**Consultation Response from: KC Environmental Health (Pollution & Noise Control)**

**2026/90441 Huddersfield Bus Station, Upperhead Row, Huddersfield, HD1 2JN**

**Discharge of details reserved by conditions 11 (bins), 15 (BEMP), 22 (Phase II Intrusive Site Investigation Report) on previous permission 2025/91604 for variation condition 2 (plans) on previous permission 2024/92302 for refurbishment comprising (phase 1): facade improvements including Henry Street entrance; replacement shop fronts; alterations to external bus apron; extension and alterations to existing barrier within the bus alighting lane adjacent to Henry Street; (phase 2): new entrance canopy; public realm improvements; cycle hub; facade improvements including replacement shop fronts**

**Condition 22 (Phase II Intrusive Site Investigation Report)**

Site Plan

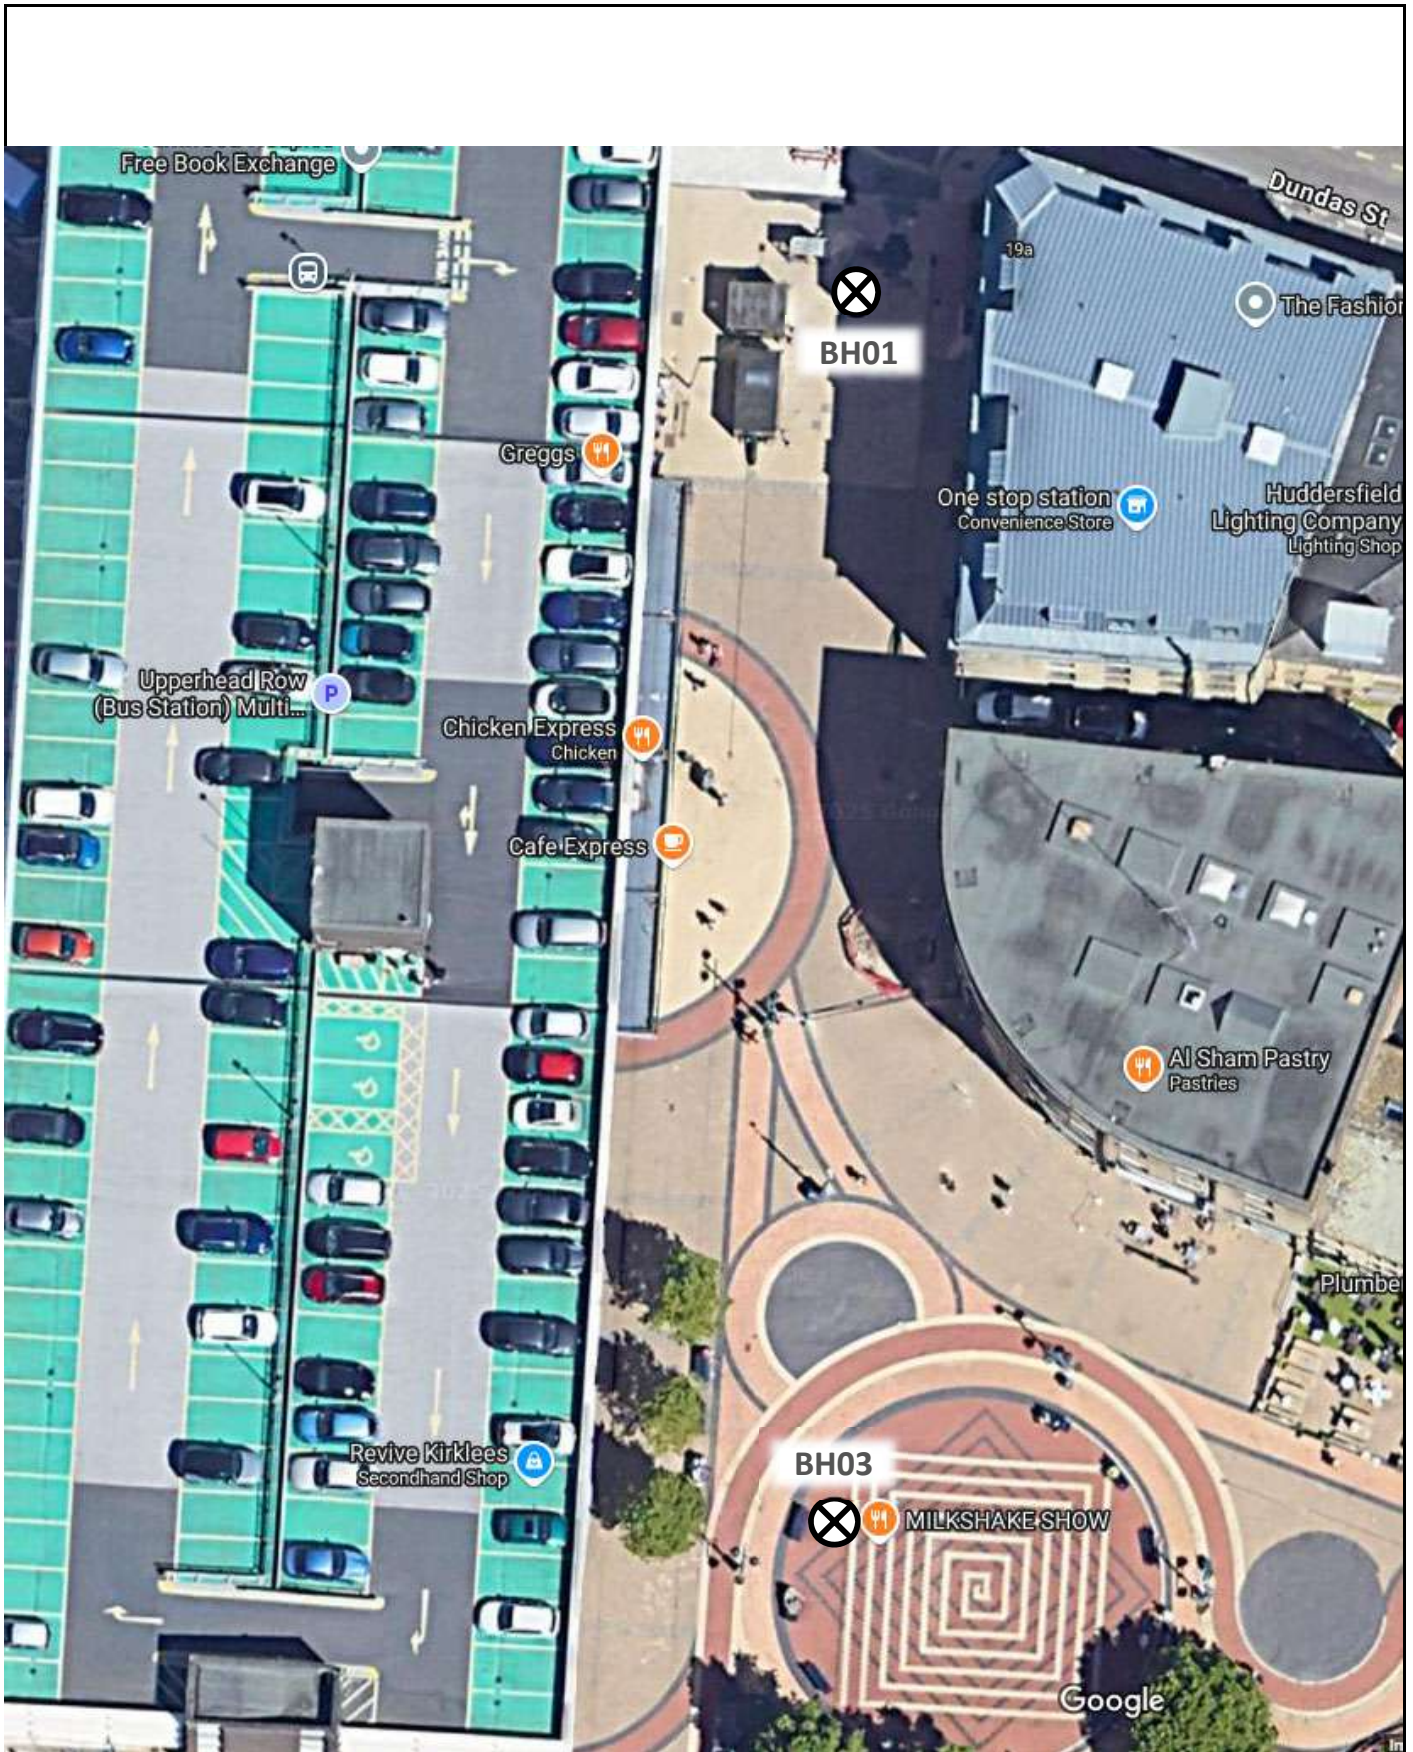
We are informed fieldworks were undertaken between the 12th & 14th, and 17th & 18th June 2025. They included two windowless sample boreholes with rotary core and rotary open-hole follow-on, with, Installation of two monitoring standpipes. The report explains, a third borehole was not undertaken due to time constraints. Good practice guidance advises a minimum of 3 investigation points and 3 monitoring locations where a gas risk has been identified.

The gas monitoring to date is provided within the RGS factual report BH01 has two results on two dates, BH03 appears to have two inconclusive results as on the first visit the gas tap was open and on the second visit silt was present on the dip meter. In addition to the inadequate monitoring no visits were undertaken during periods of atmospheric pressure below 1000mb, worst case scenario has not been demonstrated. The consultant should indicate within the

report the relevance of gas monitoring in relation to the proposed development, i.e. are enclosed spaces part of the proposal. Good practice guidance must be followed and we anticipate full monitoring results and associated commentary in an updated report.
